Attn. : Jeff Palmer – Code Enforcement Supervisor  
Cc. : Hannah Aulick and Reviewers  
Re. : SI-2024-00597 – SITE PLAN DFT  
 : 2026 Central SW  
Project No. : PR-2023-009688

I apologize for my lack of quality control on the last submittal as some of the items were on the drawings however on non-printing layers. We have prepared individual responses to each of your previous comments that did not receive clear and complete responses and verified that those responses are clearly reflected in the plots being submitted to you.

Sheet Title:  
**Landscape Plan**  
Sheet Number:  
**LS-01**

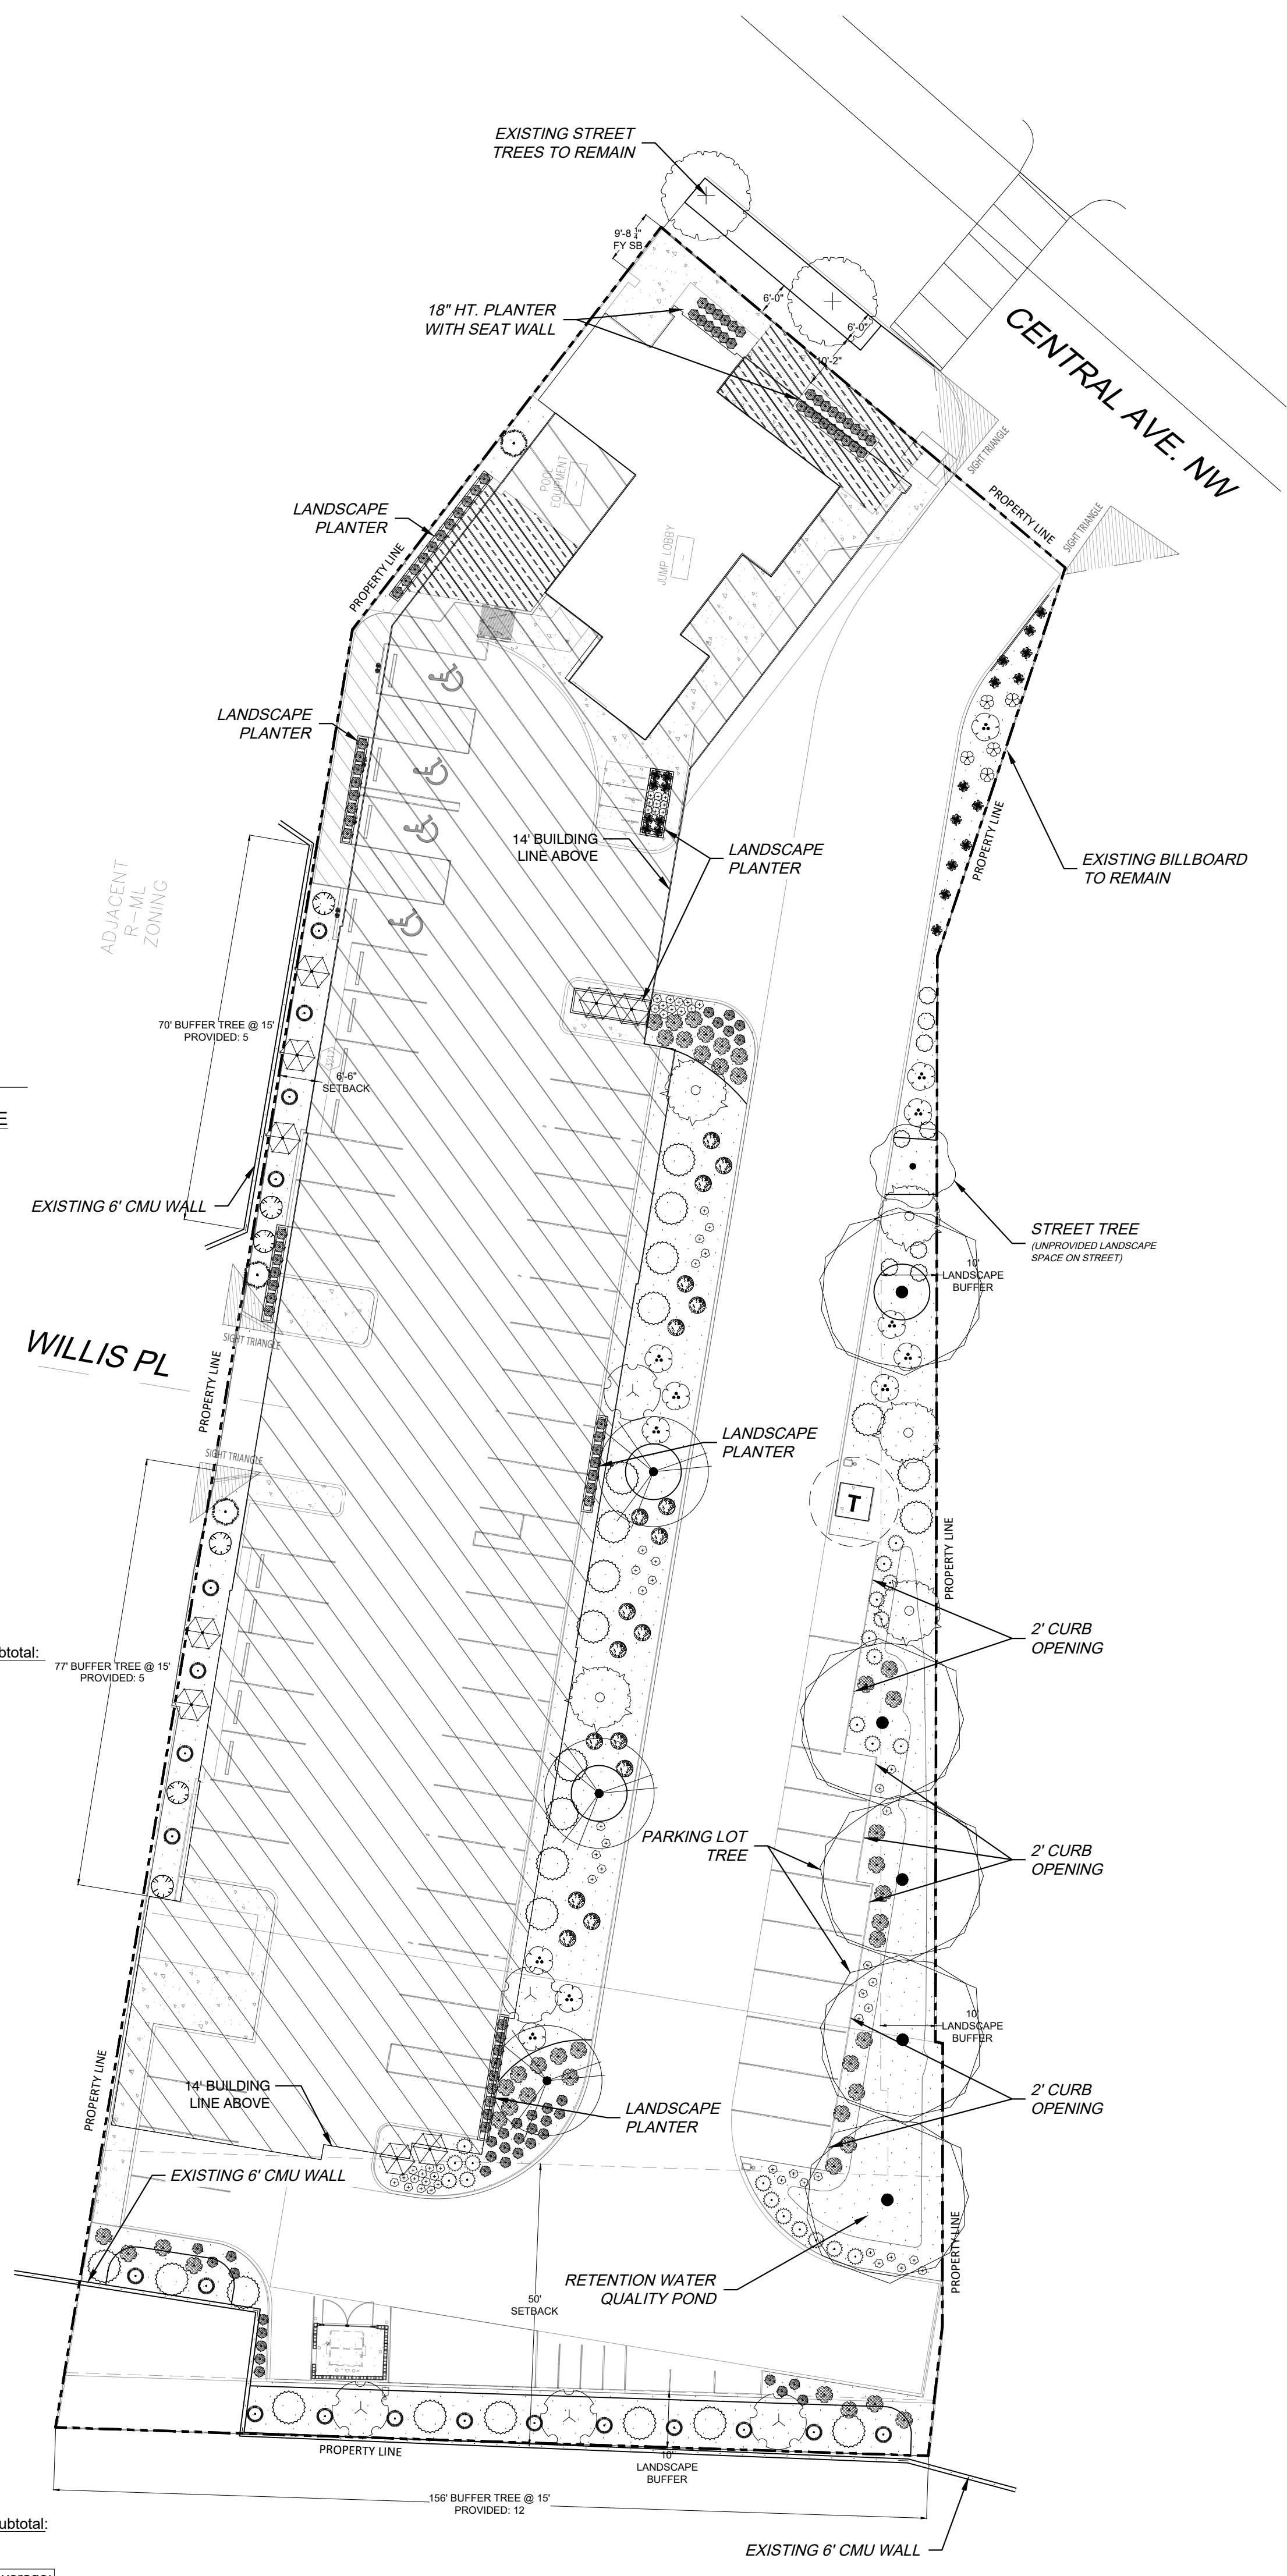
2 **Comment** - Propose larger canopy deciduous trees in larger landscaping areas to provide more shade on the hardscape. Oklahoma Redbud is generally not recommended per City Forester.

4 **Comment** - Per 5-6(C)(4)(i), shade trees planted approximately 25 feet on-center are required along all required pedestrian walkways. If the walkway is less than 25 feet long, at least one tree is required, or, where there is insufficient space for a tree, a trellis of at least 8 feet high for at least 5 feet along the walkway shall be provided. Confirm compliance.

*Comment - The clear sight triangle shall be maintained at all exits of parking areas and street intersections. Please show the site triangle on the landscape plan and demonstrate compliance with this code.*

**Response: See attached landscape drawings.**

**Response: See attached landscape drawings that show the existing 2 trees in the front walkway area.**

**Response: See attached landscape drawings.**

PLAN NUMBER
SD1-1

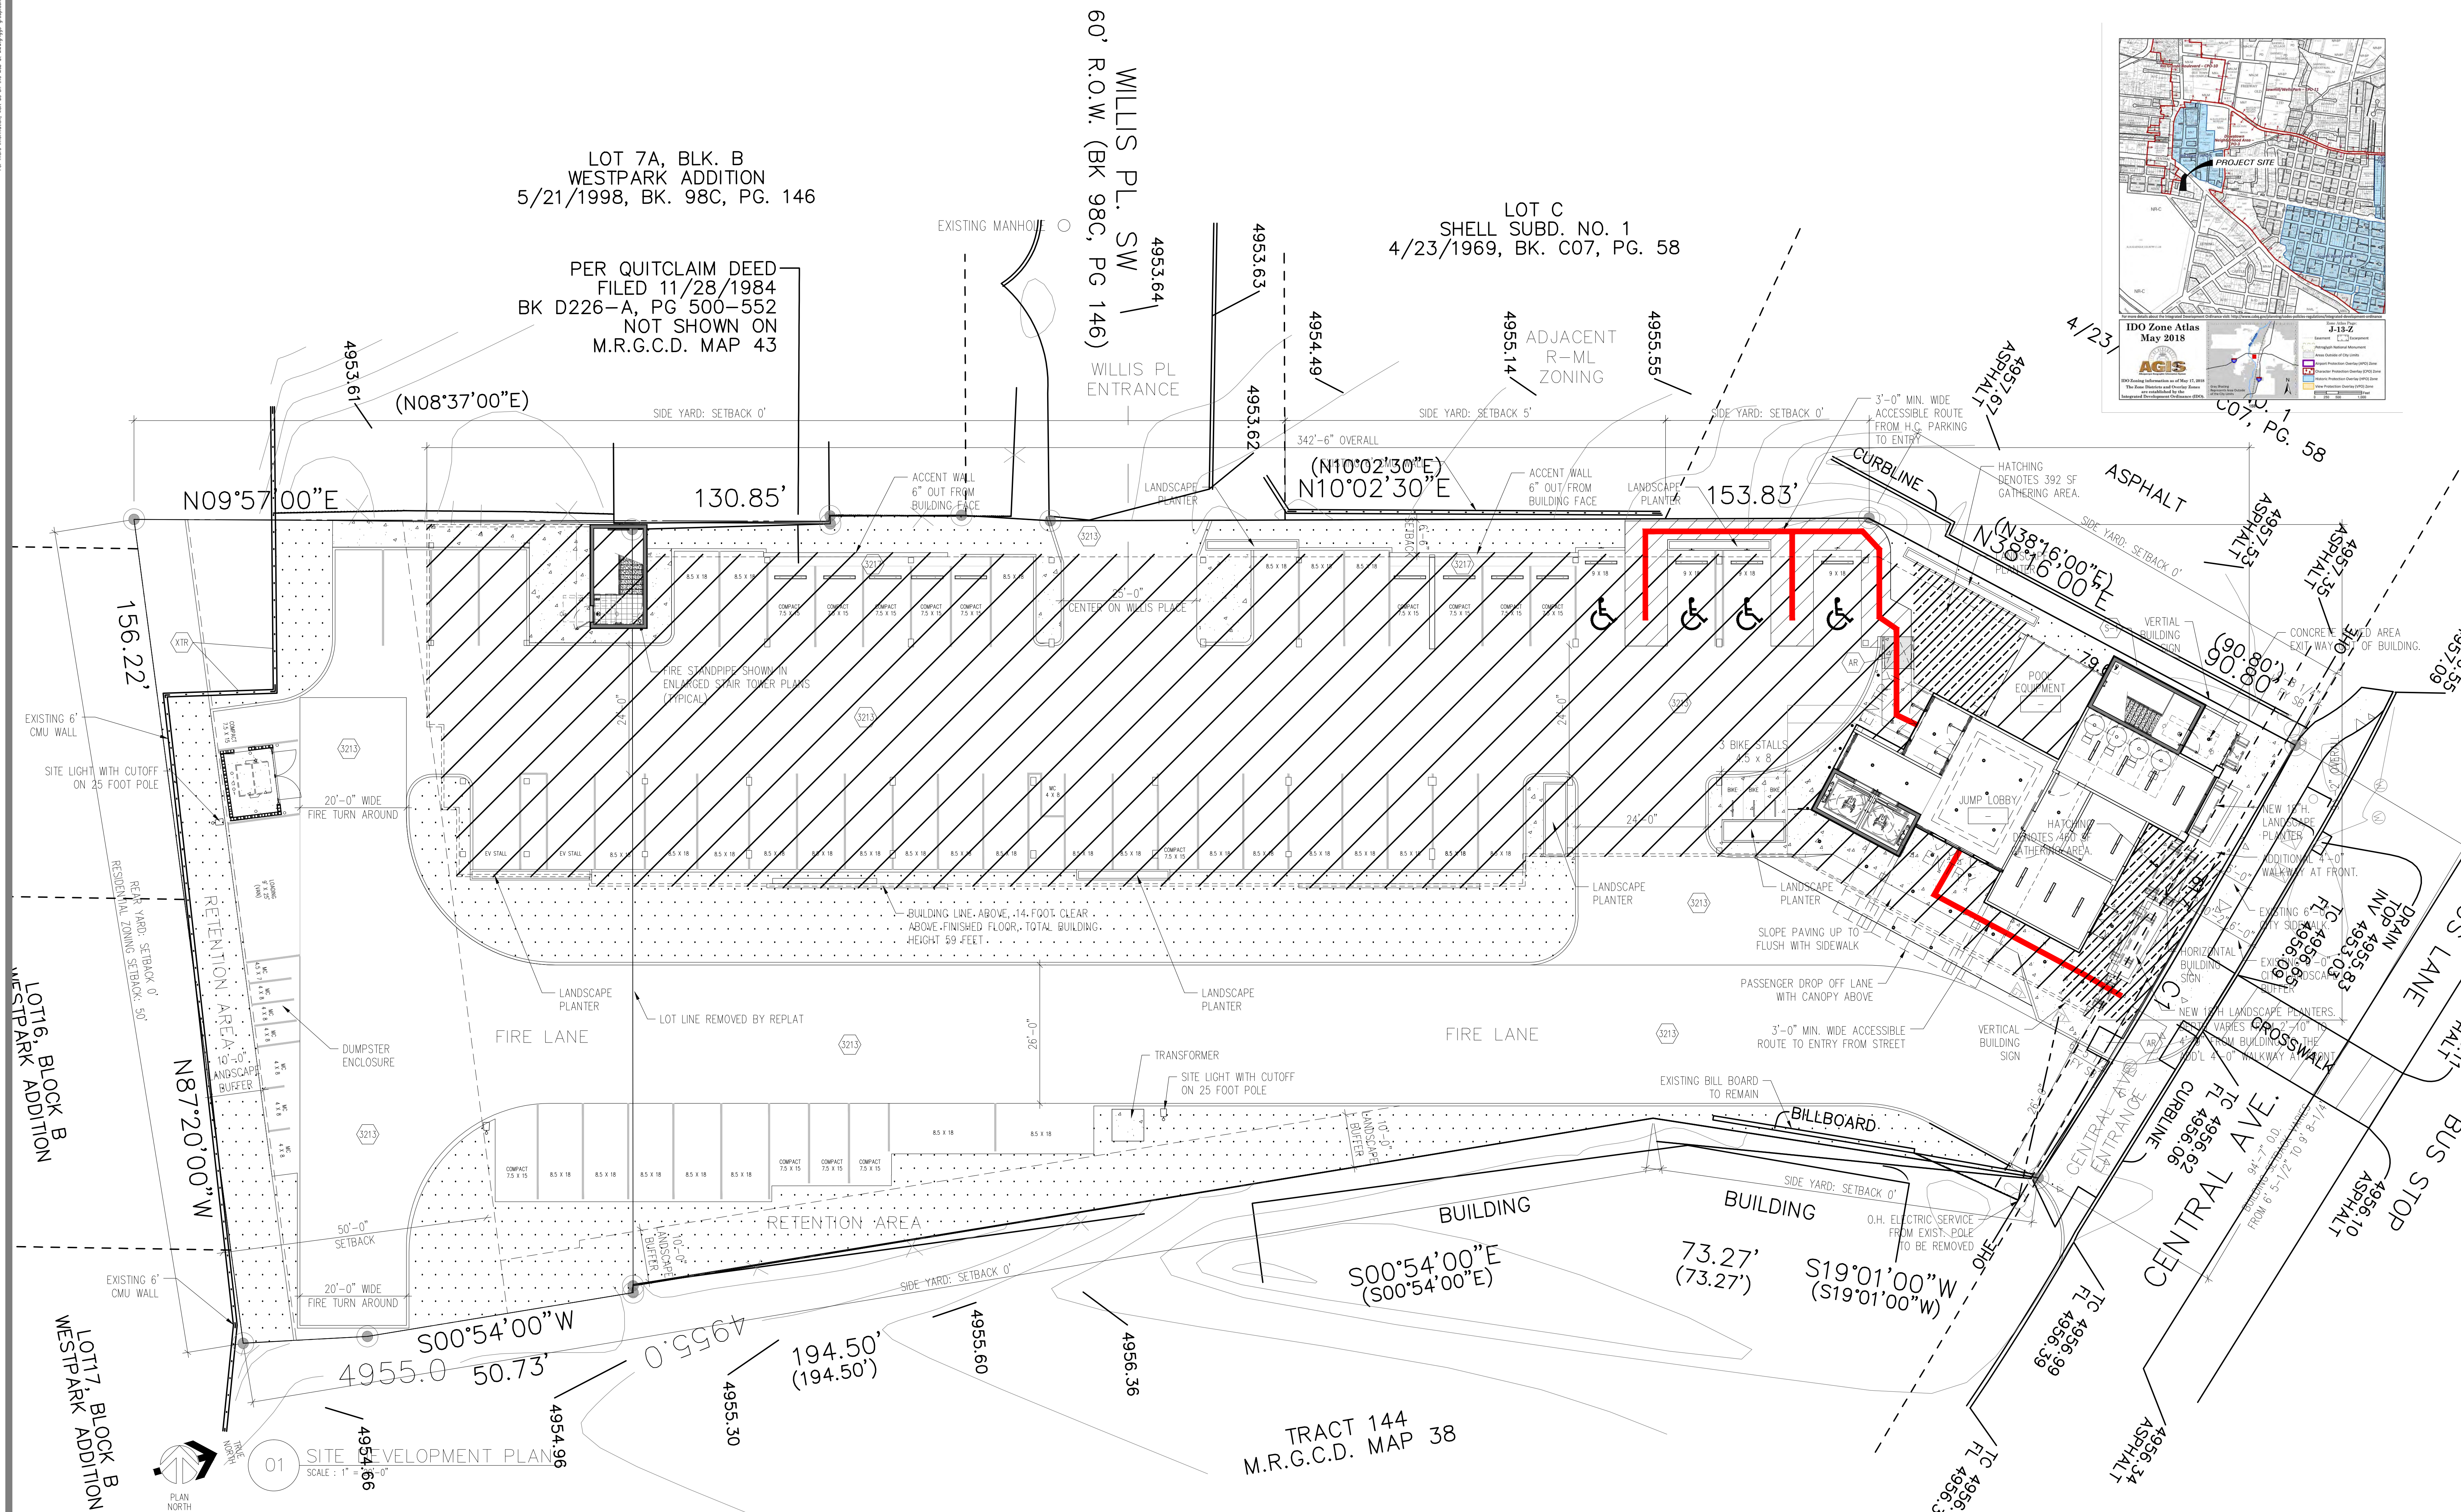
2 **Comment** - Must meet Dimensional Standards as per IDO 5-1(D), Table 5-1-2. Please show setbacks more clearly on the Site Plan.

1 **Comment** - Project and Application numbers must be added to the Site Plan. Application number is missing from the site plan.

*Response: Plan has been revised to show the dimensions of the setbacks on all sides.*

*Response: The Application Number has also been added to all the plan this time.*

U1

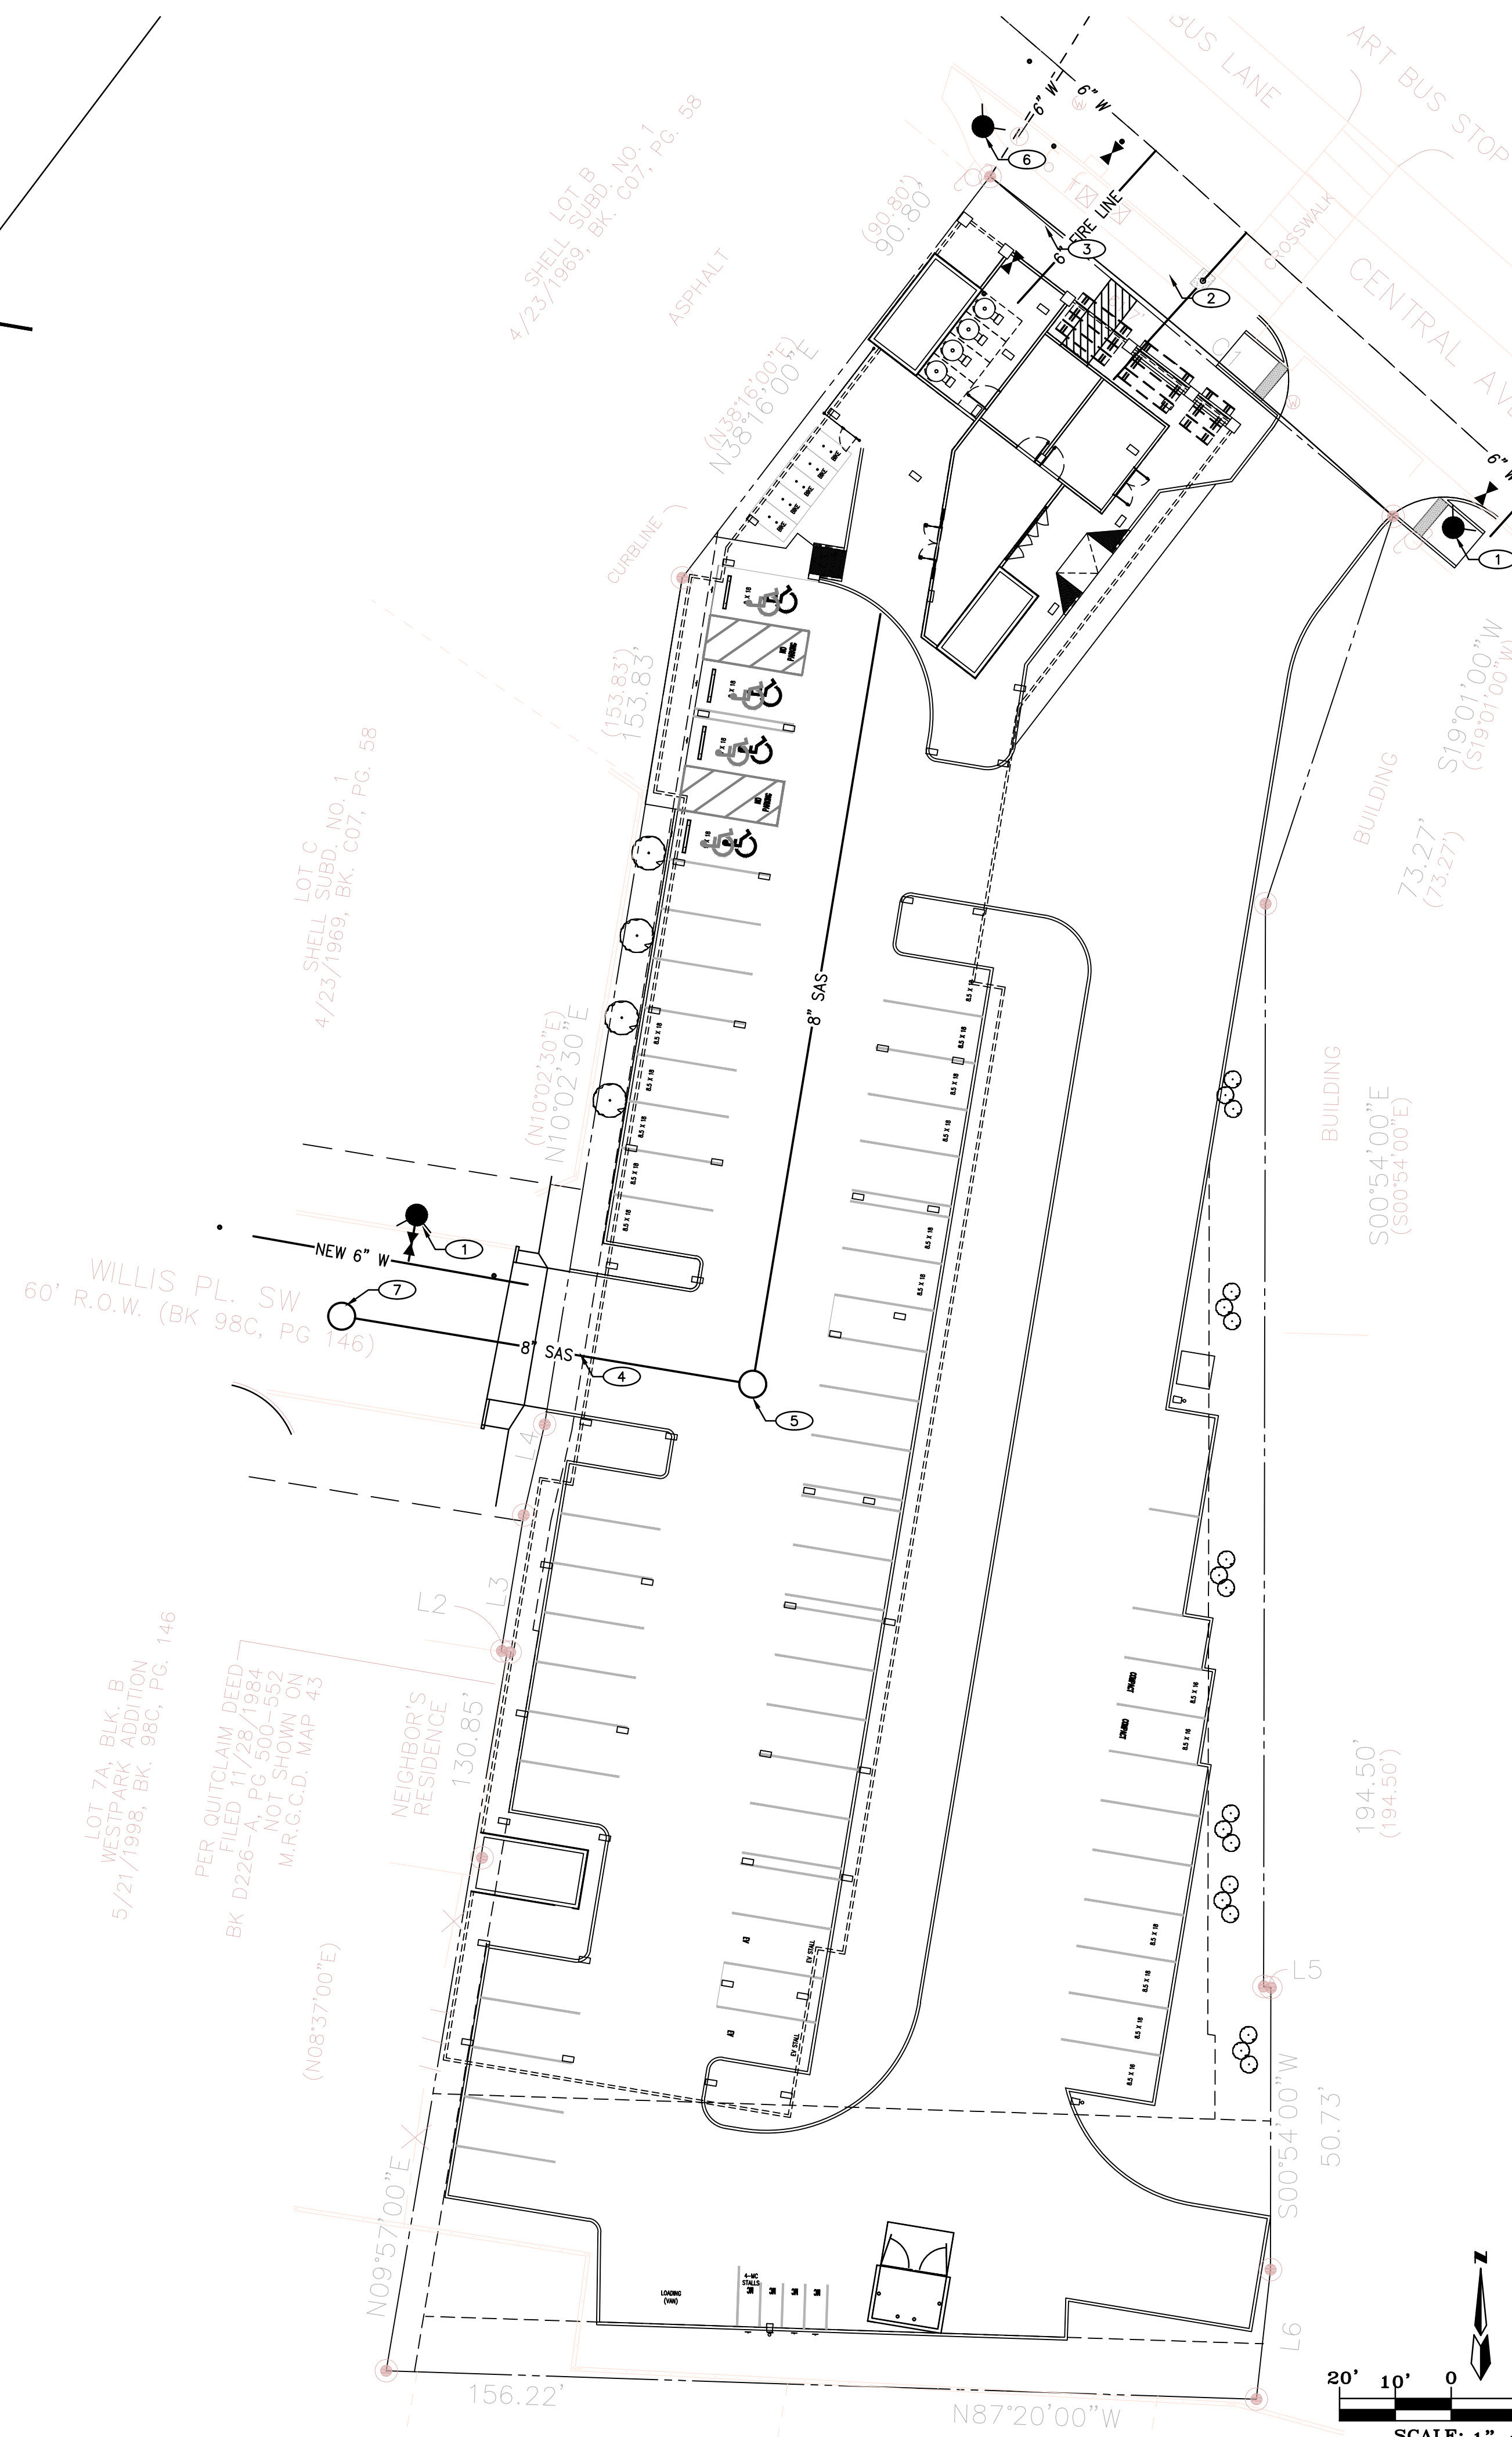
a. The utility plan was much smaller than the rest of the sheets. Please ensure the copy submitted for signature is a more legible copy. Please also enlarge the text and bolden line types for

b. Please label all infrastructure appropriately as public or private.

c. Please add the following notes:
